File No: SF17/31998  
Ref No: DOC17/345539

**RE: Notice of Exhibition - Sydney Metro City and Southwest (Chatswood to Sydenham)  
Modification 3 - Martin Place (SSI 7400 MOD 3)**

Director Heritage Operations  
Heritage Division, Office of Environment & Heritage  
**As Delegate of the NSW Heritage Council**

25 July 2017

Figure 6-2 Martin Place Station – proposed modification layout

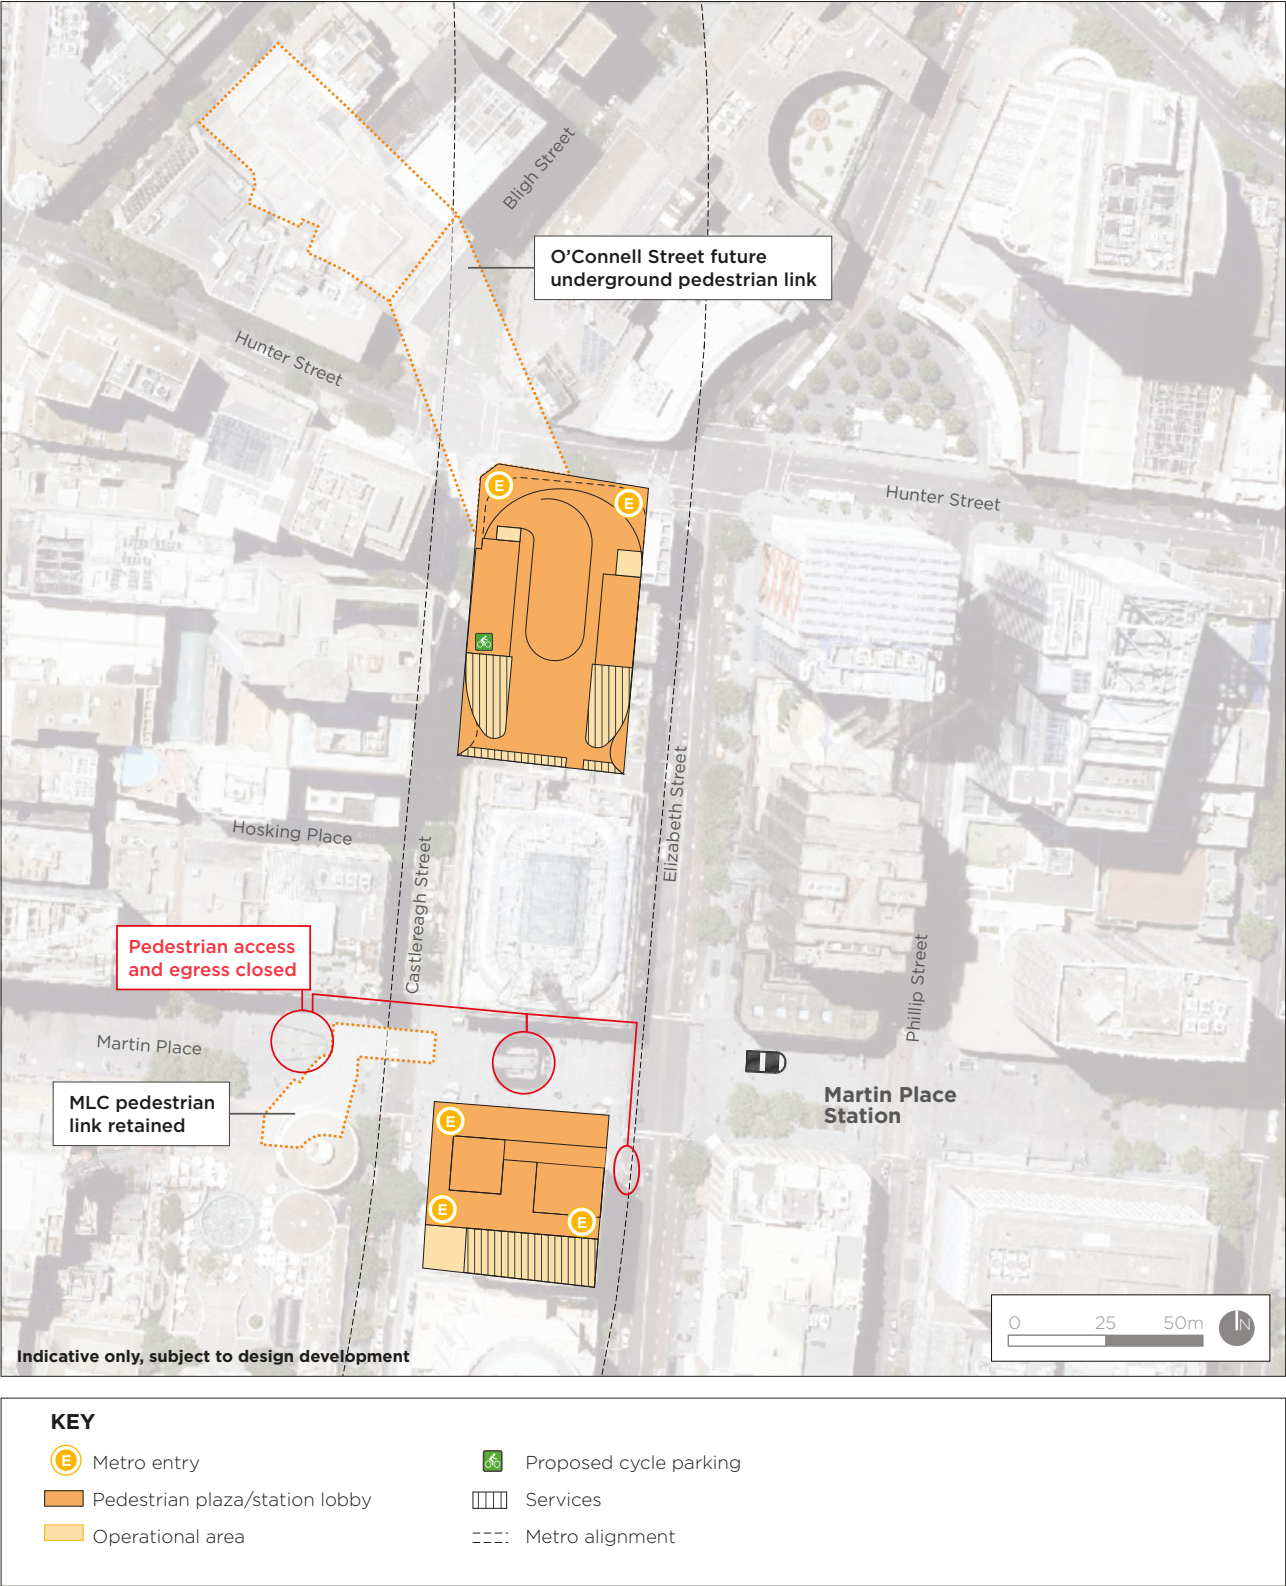
- Minor impacts from the closure of the physical connections to 9-19 Elizabeth Street. These closures will be patched. However, details of finishes have not been provided.
- Potential moderate/high impacts caused by vibration from the mined construction of underground pedestrian connections and the demolition of 9-19 Elizabeth Street.
- Moderate visual impact caused by the removal of 9-19 Elizabeth Street, which changes the context of 50 Macquarie Place.

The TfNSW report's heritage assessment recommends consultation with a heritage architect in relation to the finishes of the infilled openings between 9-19 Elizabeth Street and 50 Martin Place. In addition, the Heritage Division recommends that the Heritage Council (or its delegate) are provided with the opportunity to review and comment on the refinement of the infill design to mitigate any heritage impacts.

Figure 6-6 Proposed modification long-section showing unpaid concourse link

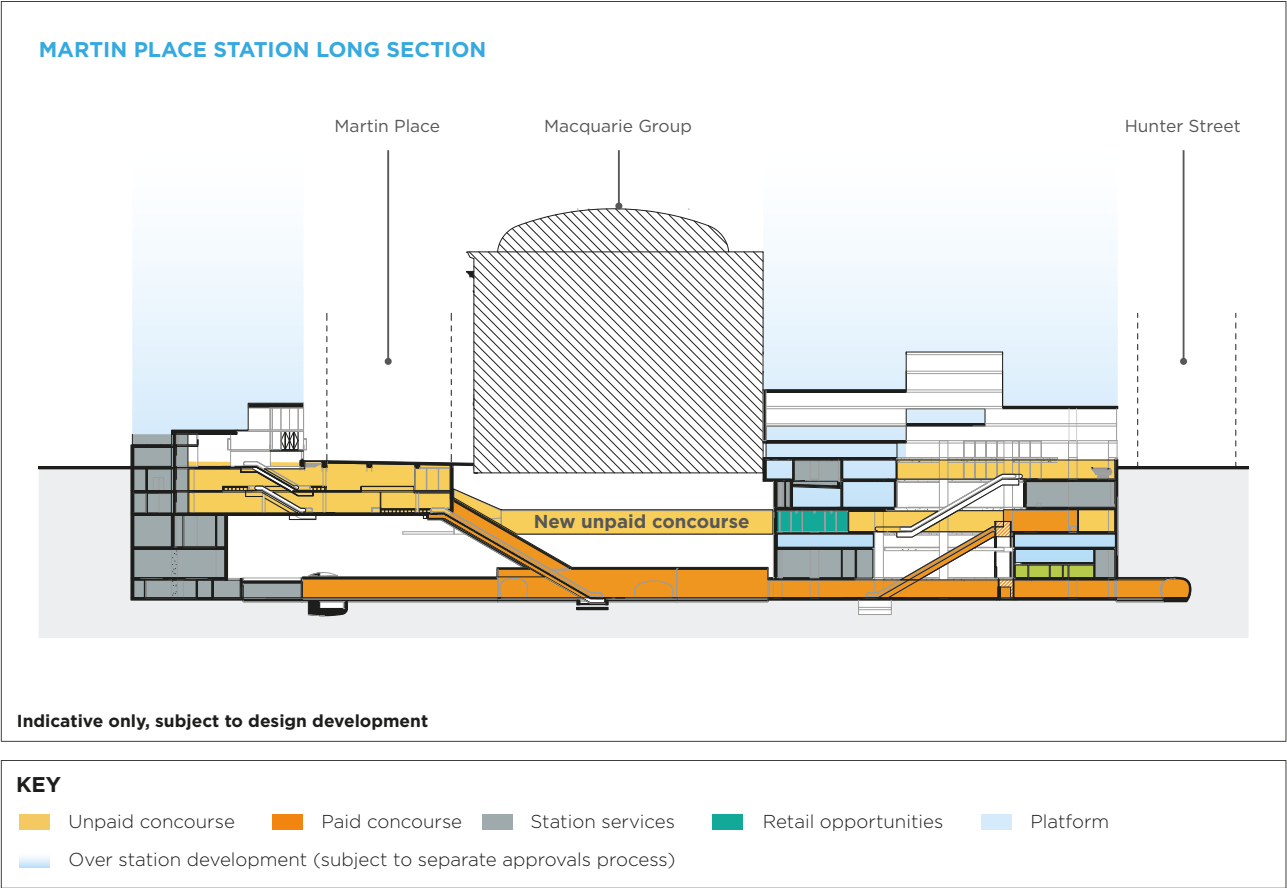
However, the proposed modification will result in a greater vibration impact to the approved project impact, which may result in vibration impacts above the screening level for cosmetic damage. Therefore, it is recommended that a detailed assessment be undertaken of the potential impacts of the increased vibration levels to the structure, fabric and significance of 50 Martin Place prior to the commencement of works. The assessment should outline any additional mitigation measures required.
